**KIRKLEES METROPOLITAN COUNCIL  
DEVELOPMENT & MASTER PLANNING SERVICE**

**DELEGATED DECISION FOR PRIOR APPROVAL FOR CHANGE OF USE  
FROM COMMERCIAL, BUSINESS AND SERVICE USES TO  
DWELLINGHOUSES**

**Reference no. 2023/CL/92836/W**

**Site Address 1st & 2nd floors, 9-13, Market Walk,  
Huddersfield, HD1 2QA**

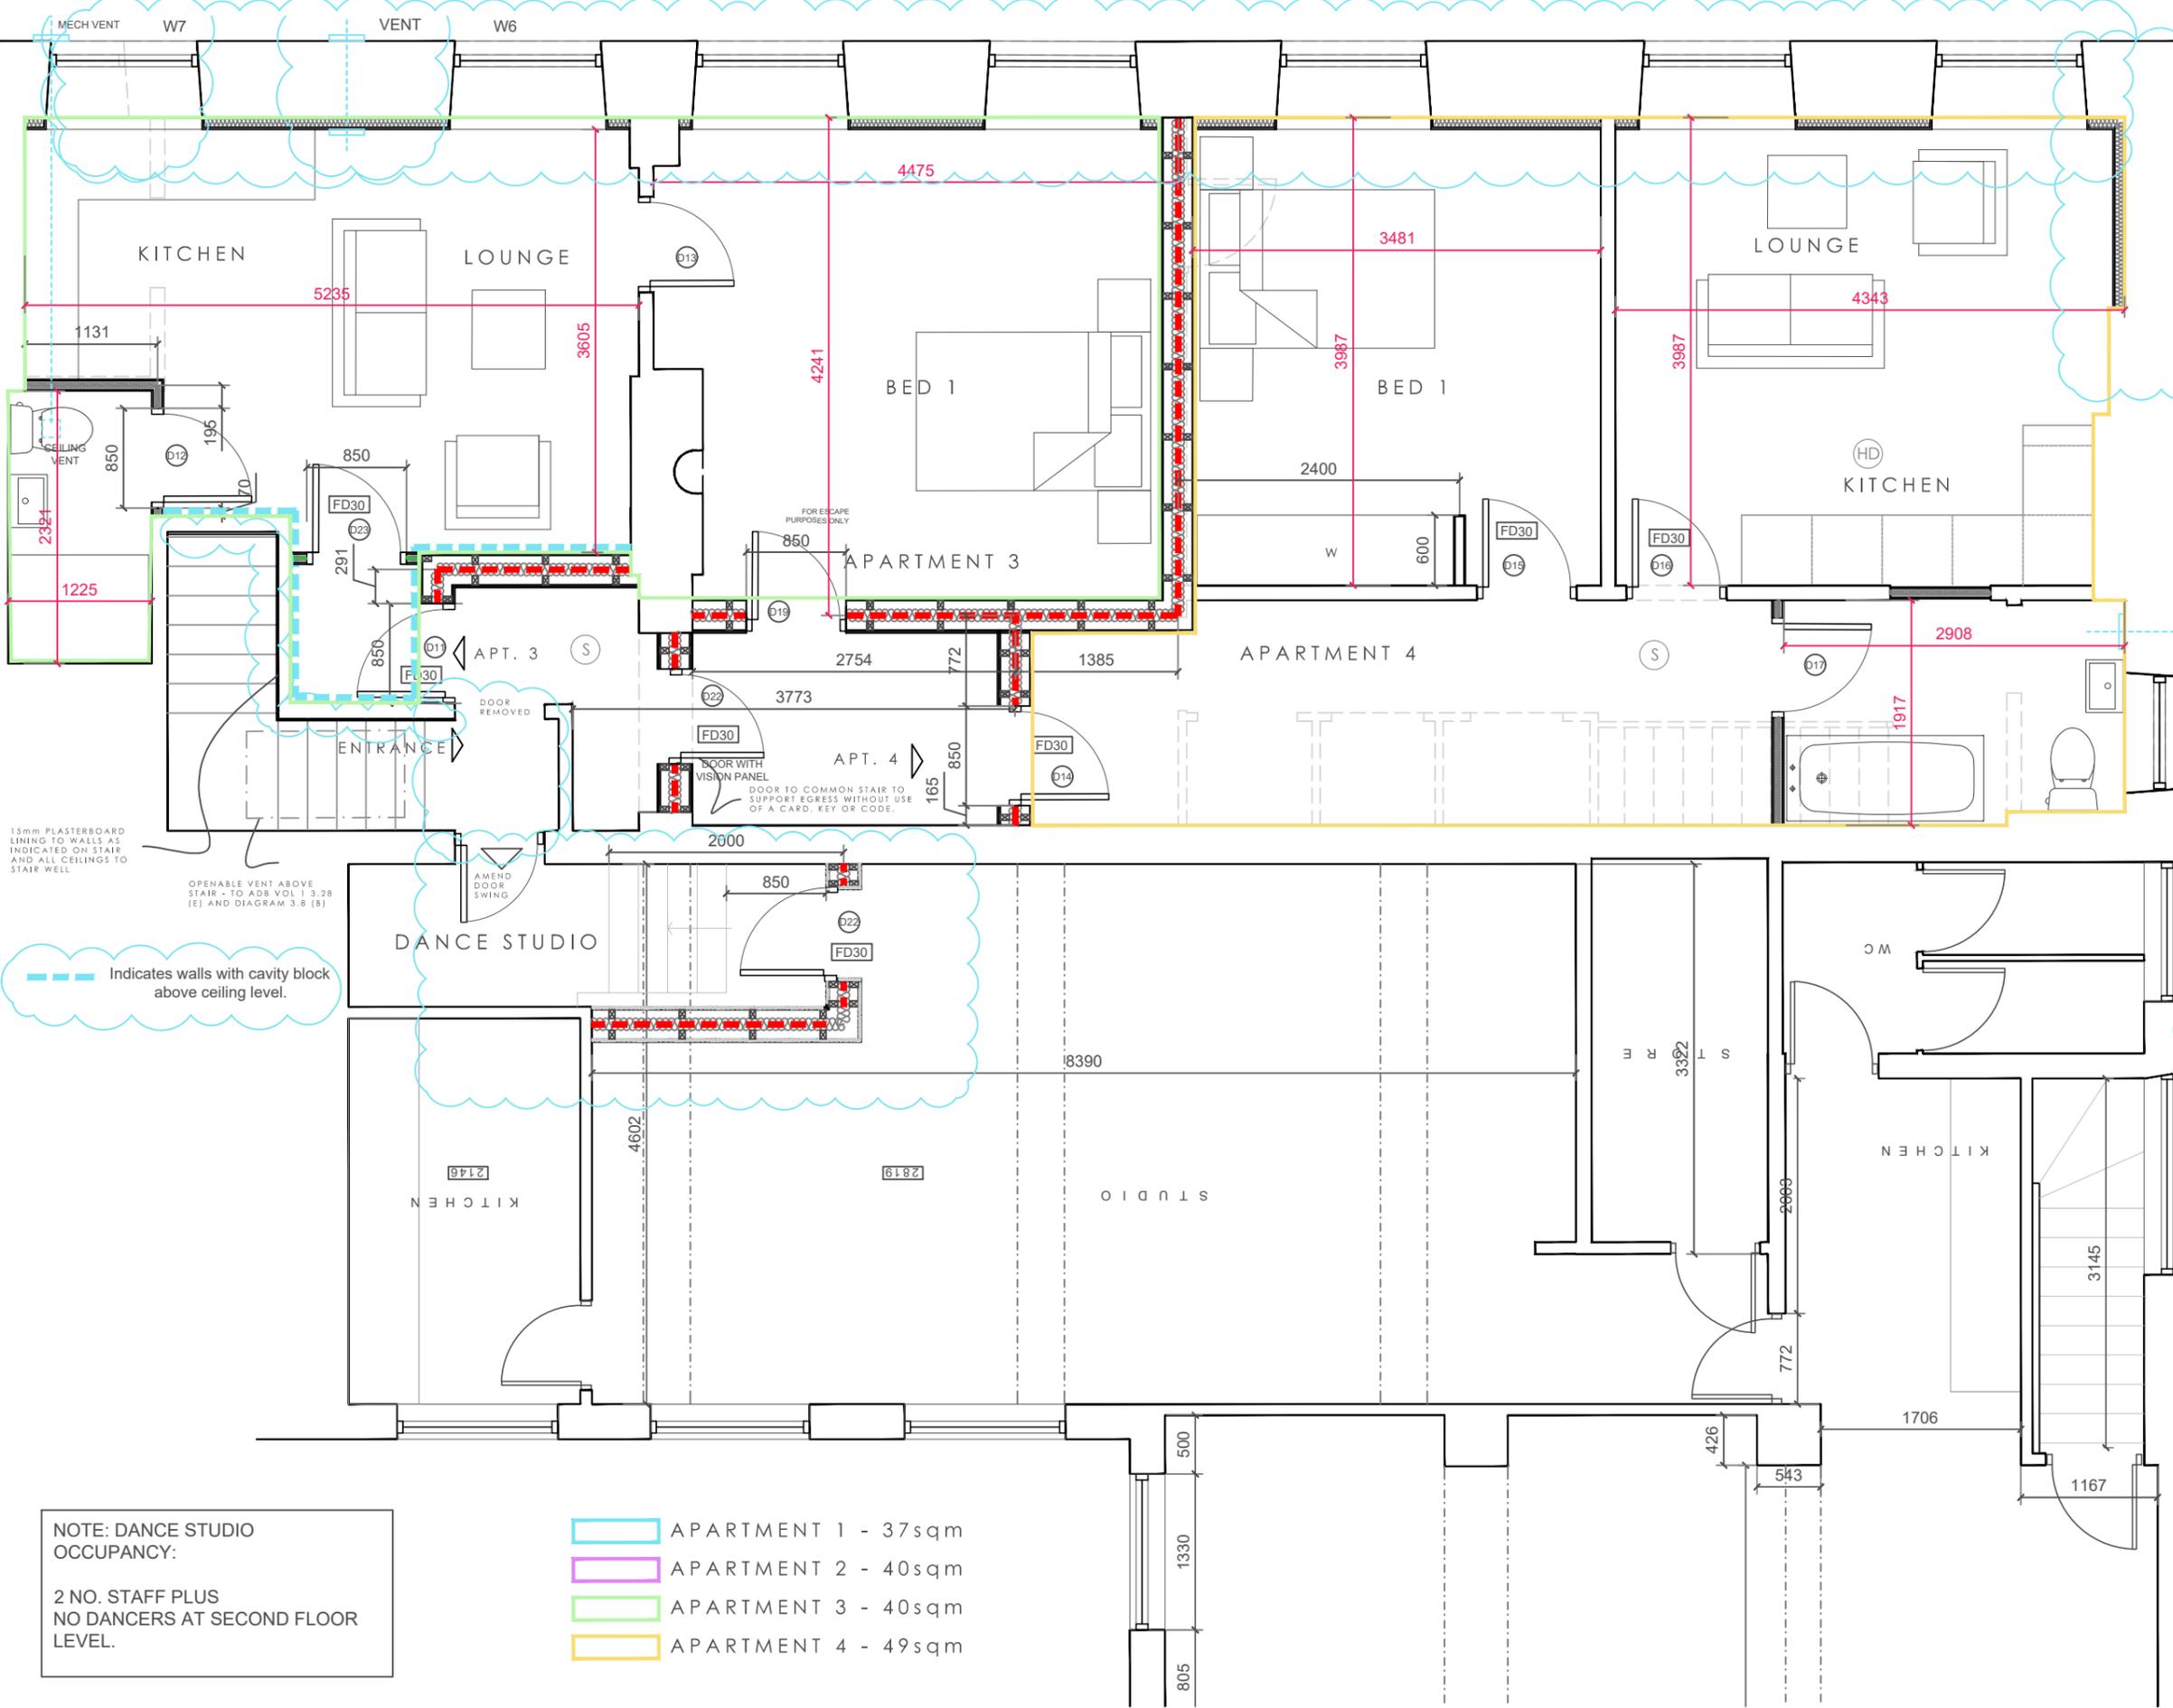
Apartment 3 is proposed to be a one bedroom second floor flat. The Technical Housing Standards document states that a one-bedroom flat for one person (minimum assessed) one storey should be at least 37 or 39 square metres dependant on whether the bathroom has a shower. In this instance, the internal accommodation is proposed to approximately 33.6 square metres which would not accord with the recommended space standards. However, the bedroom is shown to sleep two persons which requires 50 square metres of space, thus contrary to space standards.

Apartment 4 is proposed to be a one bedroom second floor flat. The Technical Housing Standards document states that a one-bedroom flat for one person (minimum assessed) one storey should be at least 37 or 39 square metres dependant on whether the bathroom has a shower. In this instance, the internal accommodation is proposed to approximately 41.3 square metres which would not accord with the recommended space standards. However, the bedroom is shown to sleep two persons which requires 50 square metres of space, thus contrary to space standards.
